About the application

Application number: 2026/90452	
What is the application for?:	Erection of dwelling and associated works
Address of the site or building:	Land adj, Lower Common Lane, Scissett, Huddersfield, HD8 9HL
Postcode:

Proposed Site Plan 1:200

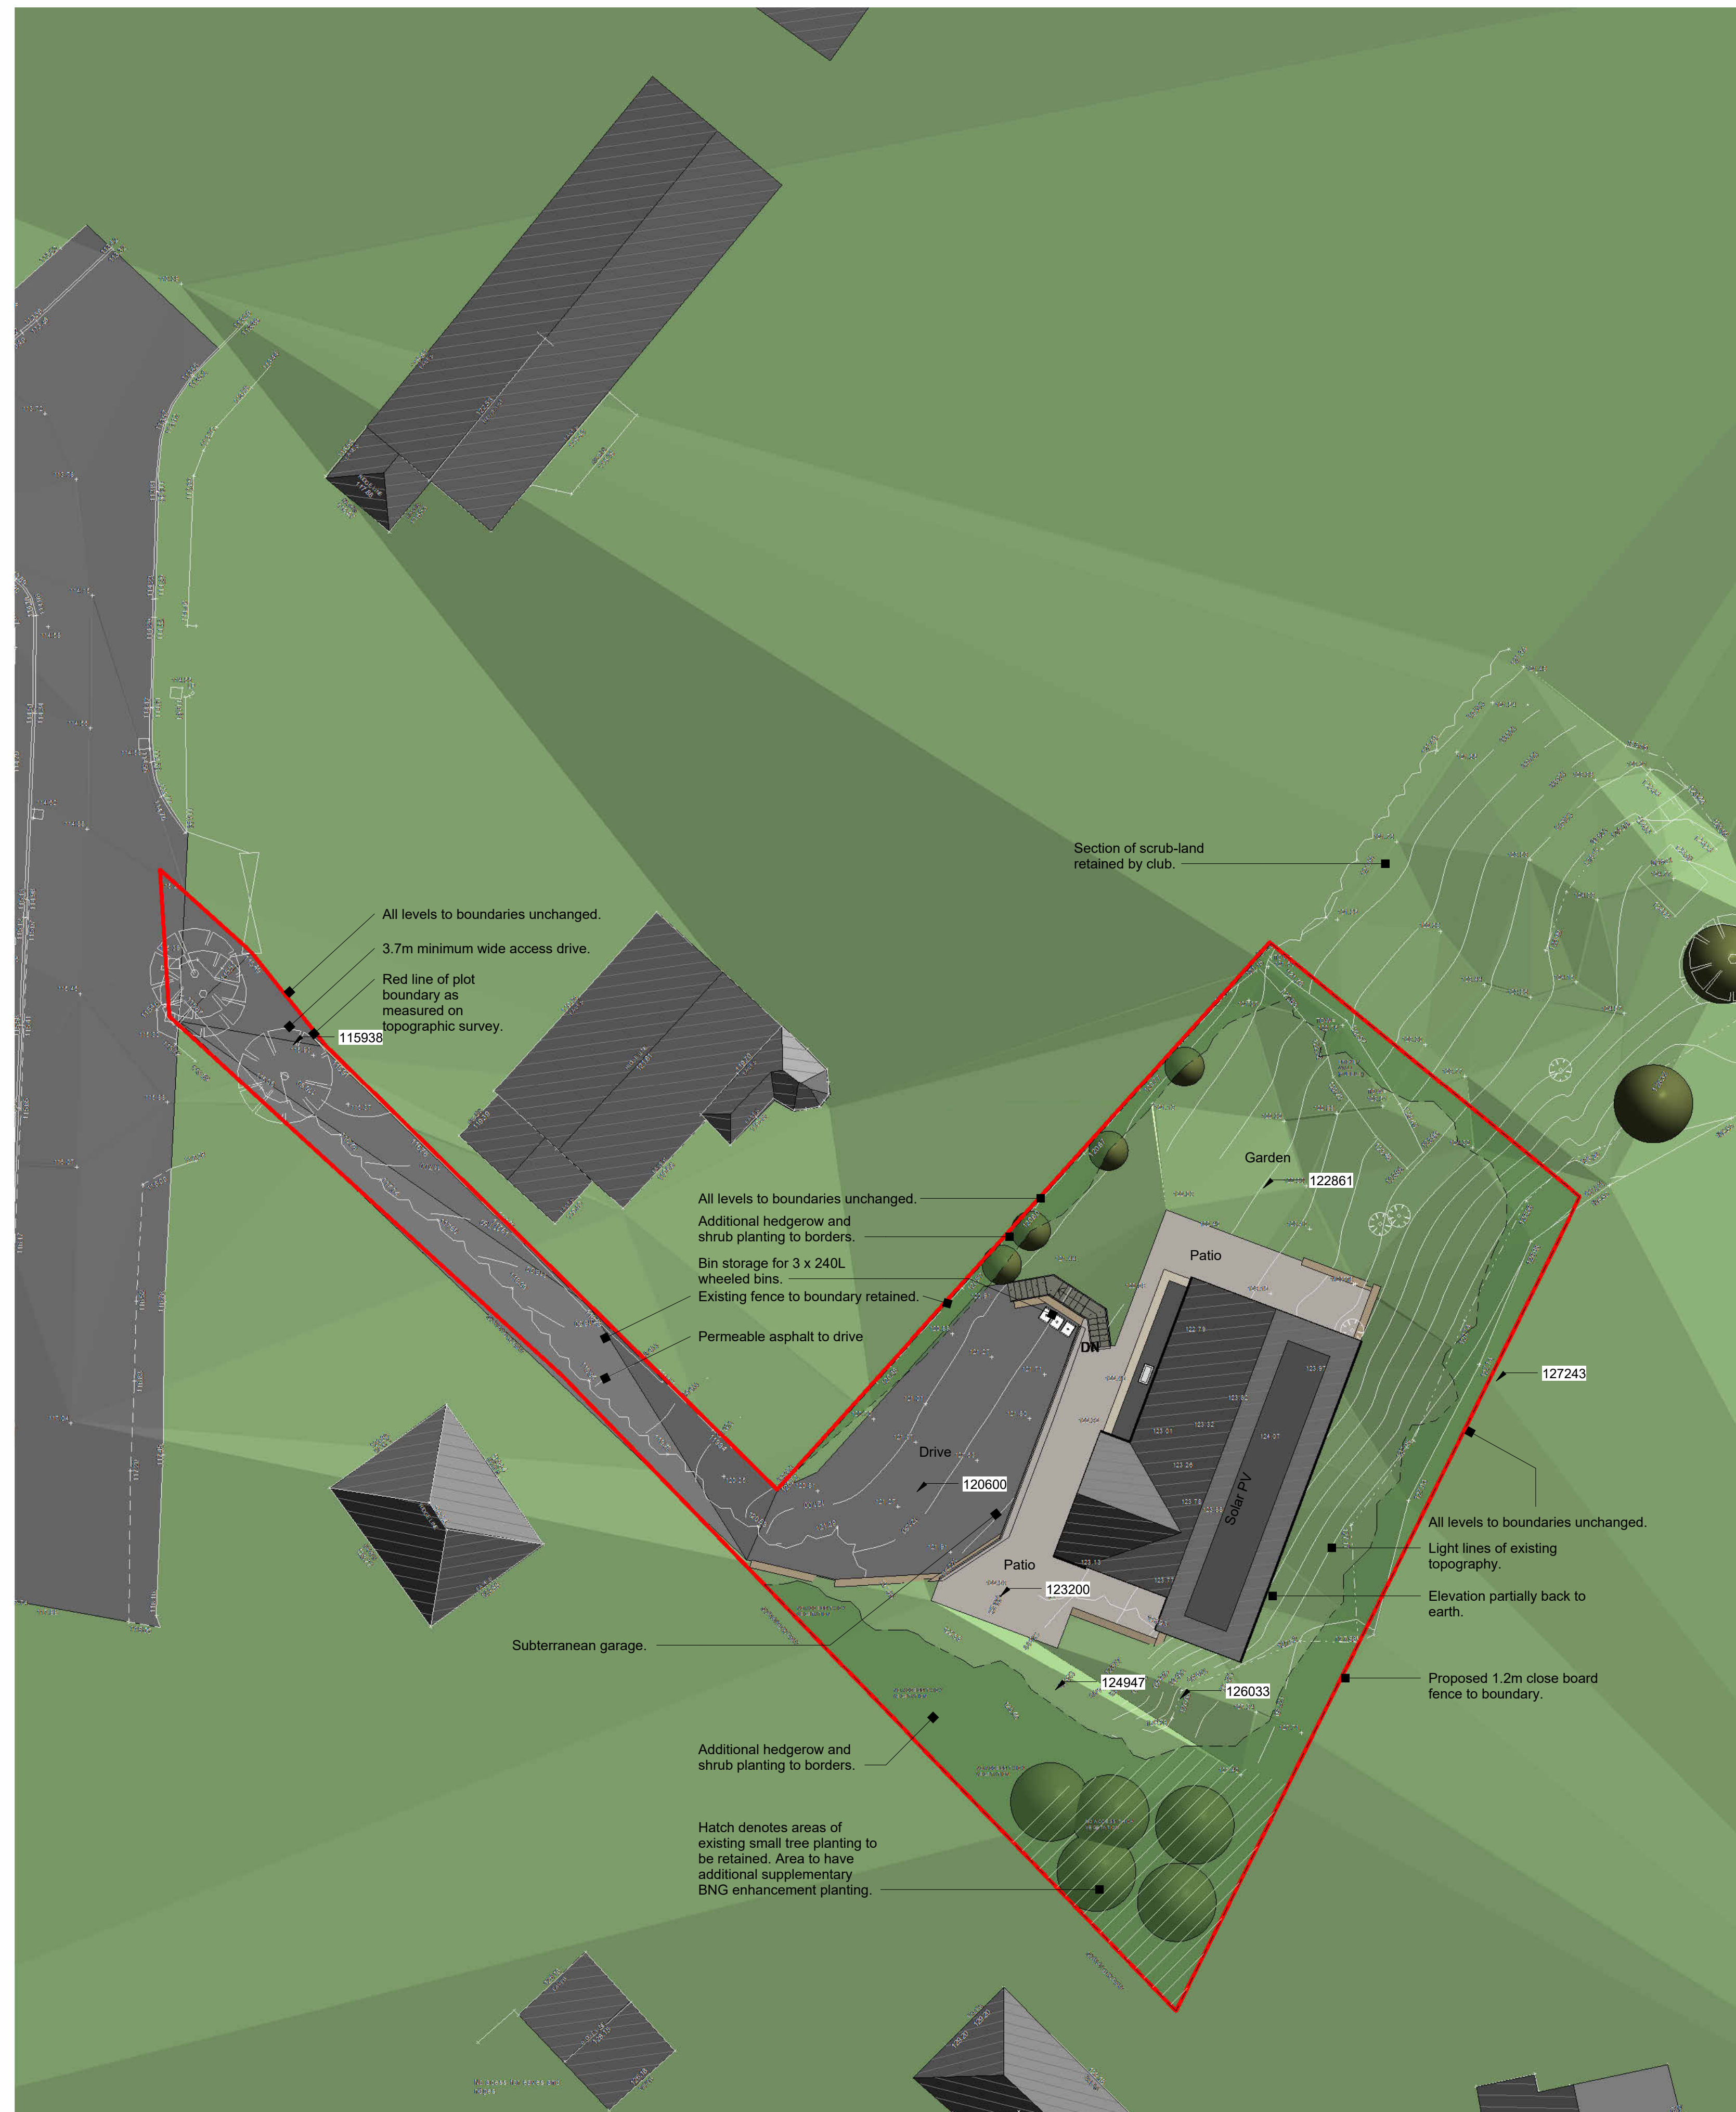
Type of comment: An objection	
Do you wish your comments to be published on the website anonymously?	<input type="checkbox"/> Yes
<p>Whilst the proposal to build on this Grey Belt is good, the access to the land shouldn't be from Lower Common Lane, as it don't have the ability to provide the correct highway sightlines. To provide the correct sightlines will require 3rd Party Plan and this will need securing so these aren't blocked going forward.</p> <p>Also the access will clash with the Hillside Day Nursery.</p> <p>Can't consideration be made to provide access to this land from Springfield Avenue removing the issue of access?</p>
